Bent Grass East Commercial  
Filing No. 3  
Updated Traffic Impact Analysis  
PCD File No. SP2010  
(LSC #204660)  
March 5, 2021

LSC Responses to  
EPC TIS Redlines <sup>1</sup>

# LSC Responses to EPC TIS Redline Comments

TYPICAL PRIVATE ROAD CROSS SECTION
SCALE: 1" = 10'

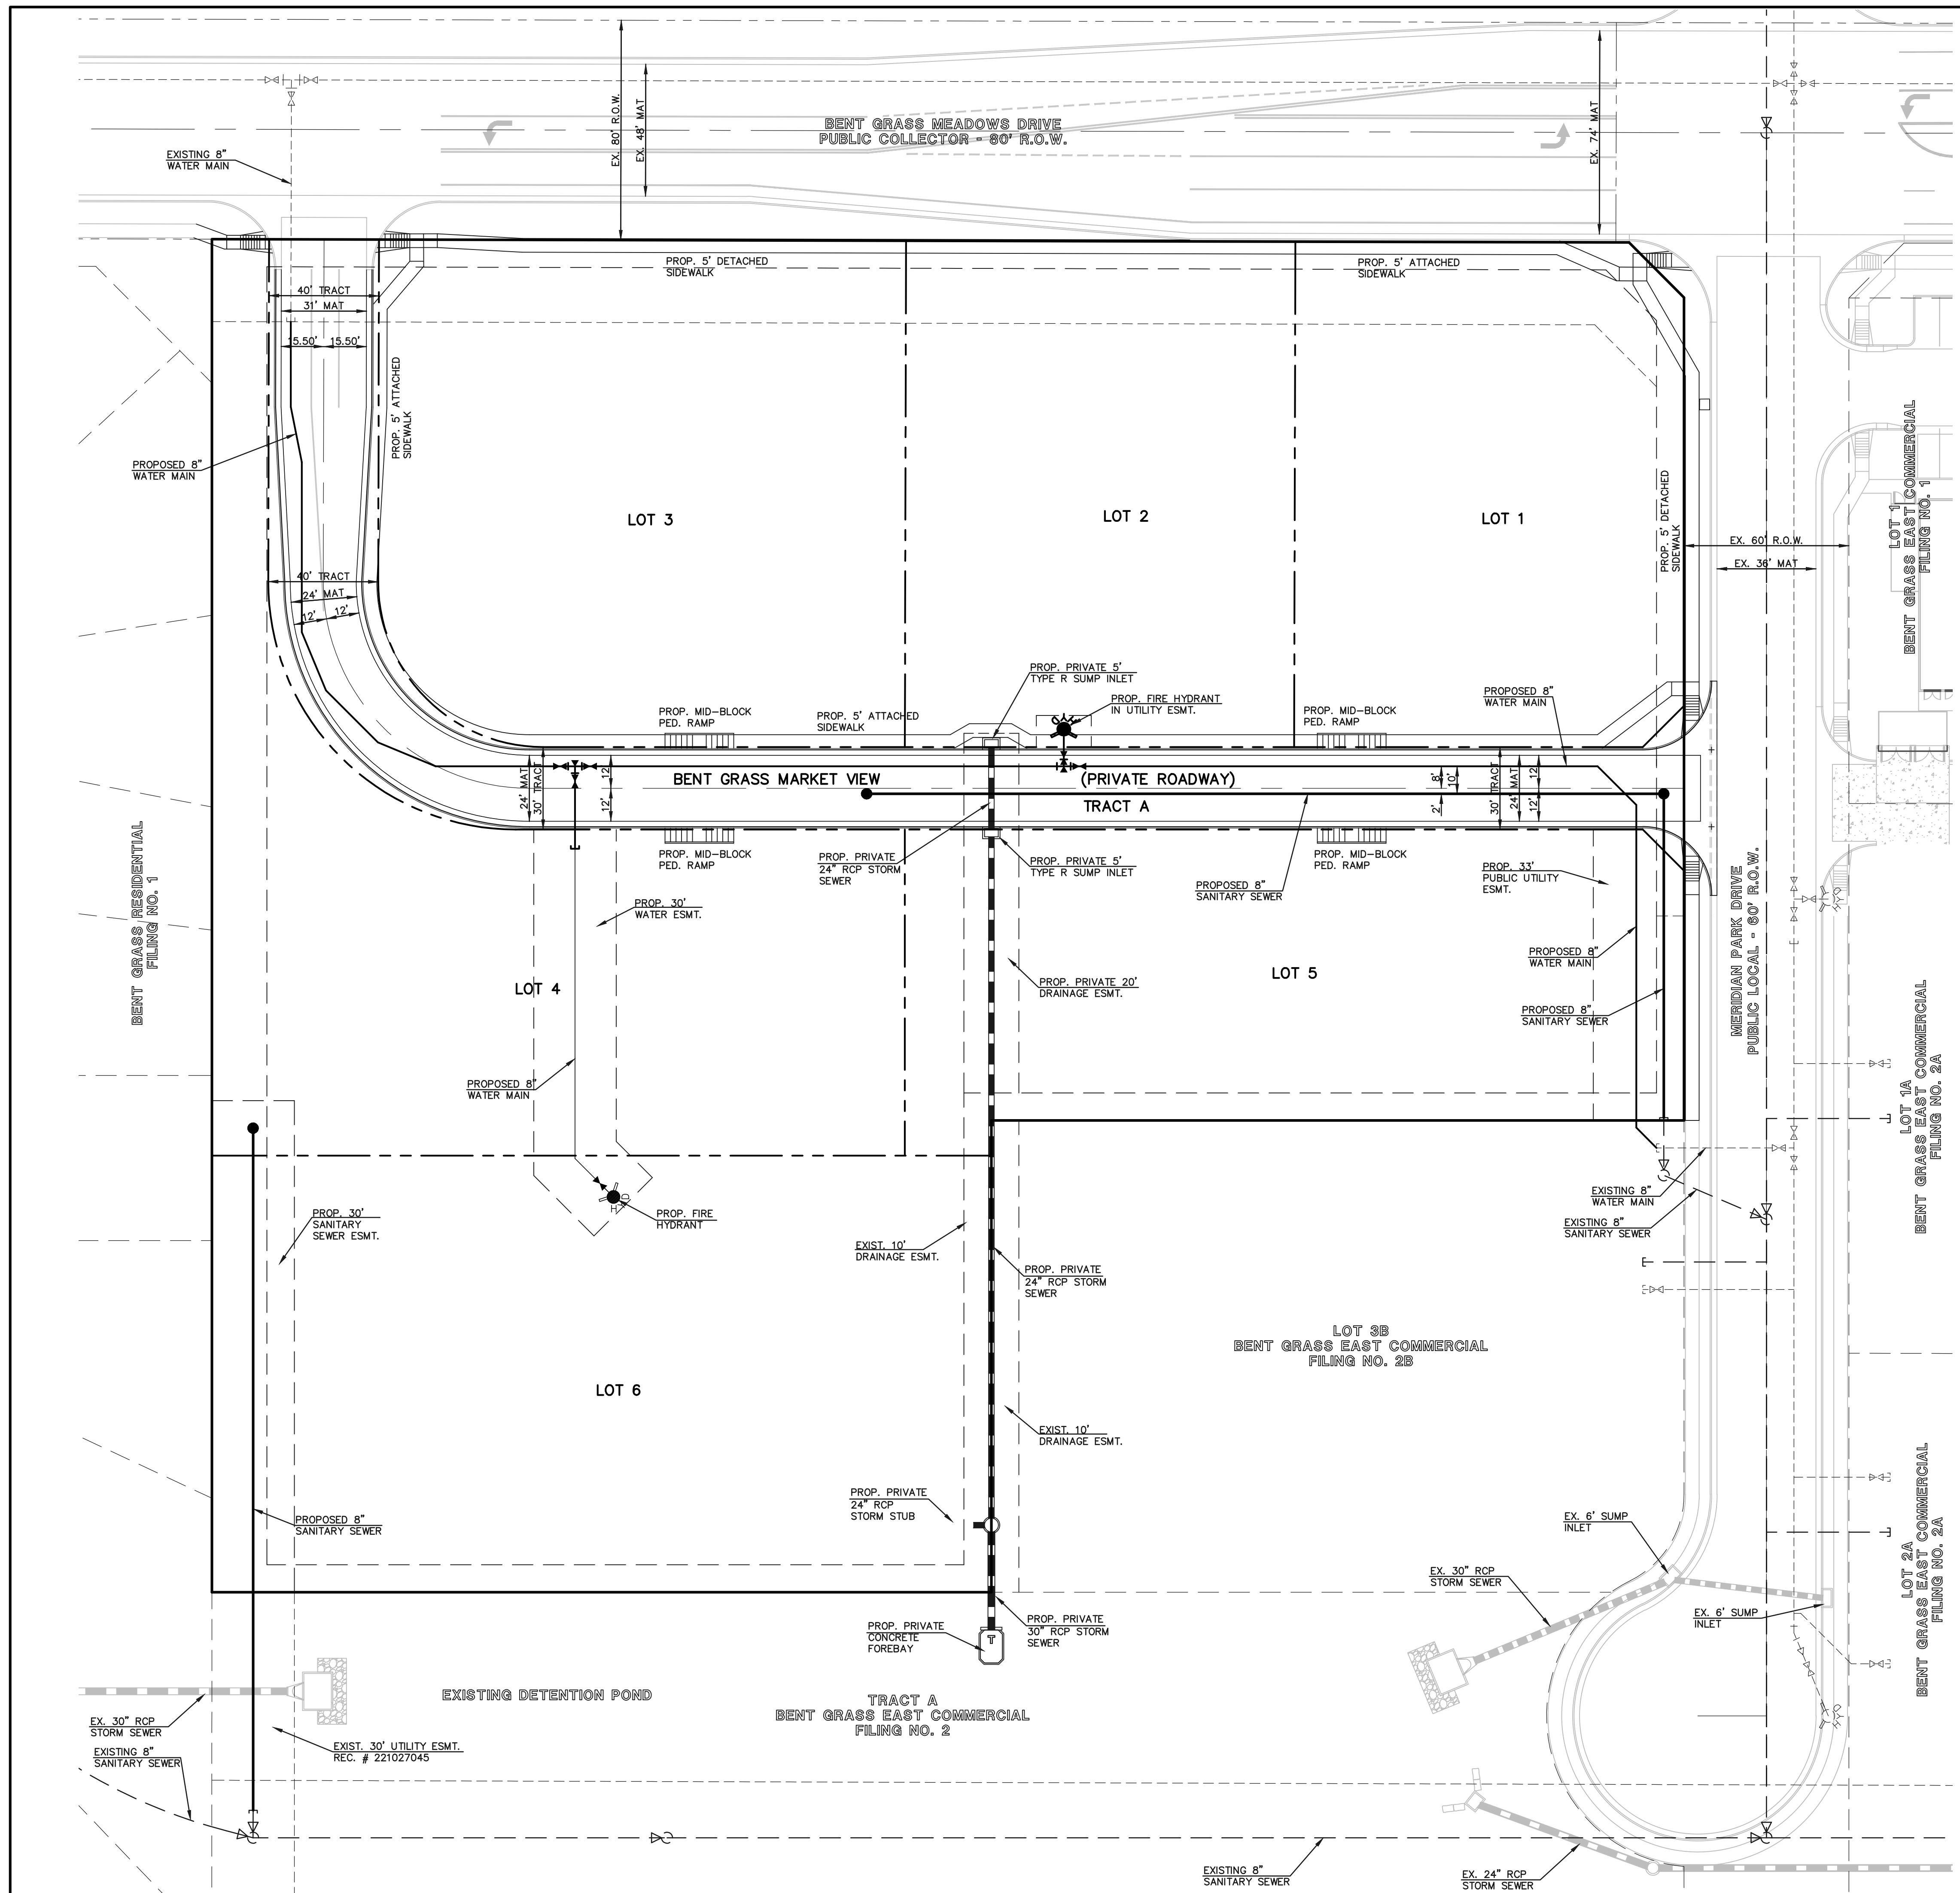
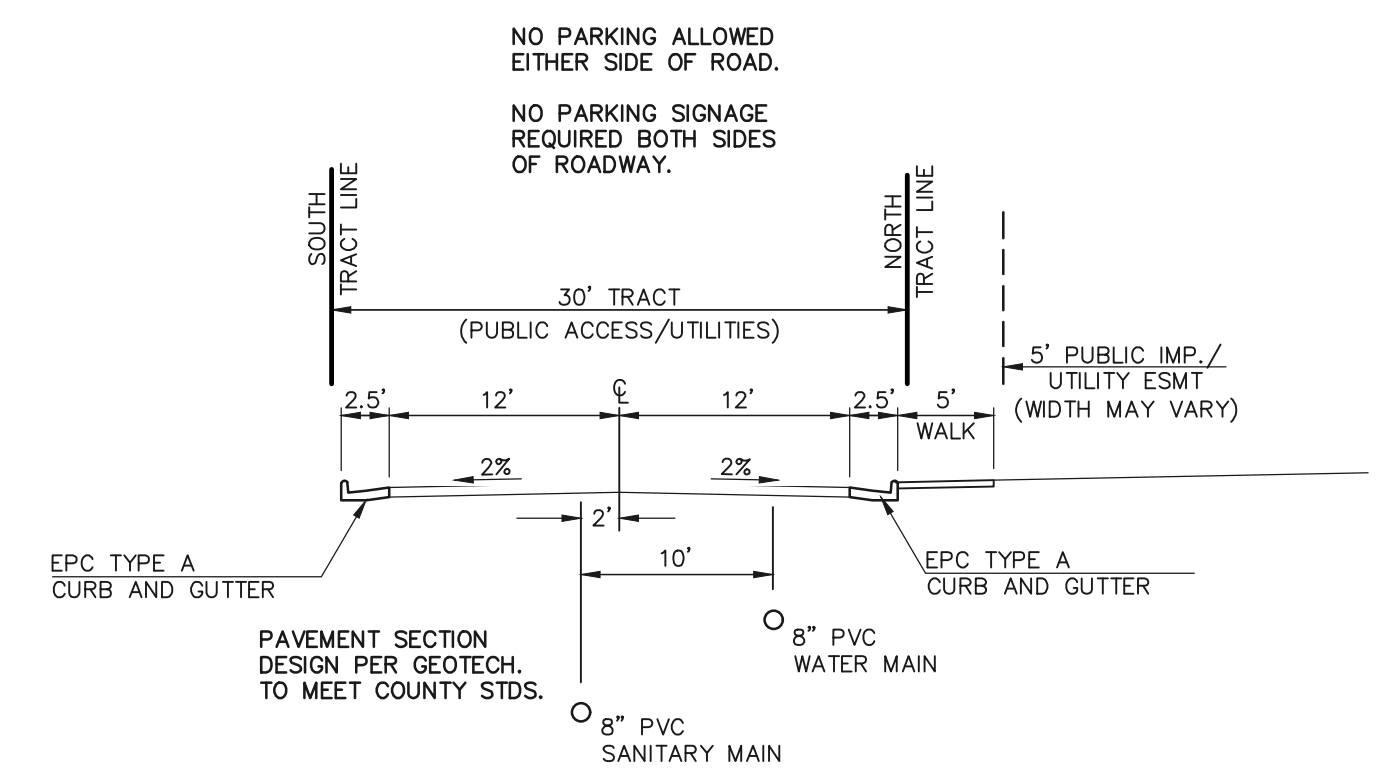
Provide the classification of the proposed private road. Provide justification/analysis for the 24' wide pavement proposed for the private roadway vs a larger cross section. Based on the ADT the urban local low volume cross section proposed does not appear adequate. Analyze whether the proposed roadway is sufficient for the design vehicle(multi-unit trucks) of this commercial development. Turn movement templates (auto-turn) should be provided for the proposed centerline radius of 75' as well as at the intersection of the private roadway to Meridian park Drive and Bent Grass meadows.

*Analyze whether the proposed roadway is sufficient for the design vehicle(multi-unit trucks) of this commercial development. Turn movement templates (auto-turn) should be provided for the proposed centerline radius of 75' as well as at the intersection of the private roadway to Meridian park Drive and Bent Grass meadows.*

LSC Response: LSC suggests a classification of "Commercial Local [private]" for the private road.

LSC Response: This street is intended only to serve the adjacent commercial lots and not through traffic. Each lot will be required to provide sufficient on-site parking as on-street parking will not be allowed. With no on-street parking, two-way traffic will be maintained. As this will be a relatively short, local commercial street serving a minimal number of commercial lots, a center two way left turn lane would not be necessary to separate left turning traffic from through traffic at each of the internal lot driveway access points. The roadway has a short length and as such, trip lengths will be short. The narrower width combined with the short length will geometrically limit higher speeds.

LSC Response: An urban local low volume street is a **residential** street classification which allows individual residential homes to front the street, on-street parking, and allows vehicles to back out onto the street. On-street parking will not be allowed on this street and two-way traffic will be maintained. Each individual lot will be required to provide circulation such that vehicles will not back onto the street. As a commercial street, higher traffic activity is expected and tolerated, compared to a minor local residential street.

LSC Response: Please refer to the Autoturn exhibit for truck turns into/out of the private road and passage through the site on the private road. The site development plan for each individual lot will address lot access design and site circulation to accommodate the anticipated design vehicle – either single unit or multi-unit trucks. The radii at the intersections of the private road/Meridian Park Drive and the intersection of the private road/Bent Grass Meadows Boulevard can be adjusted to accommodate the design vehicle.
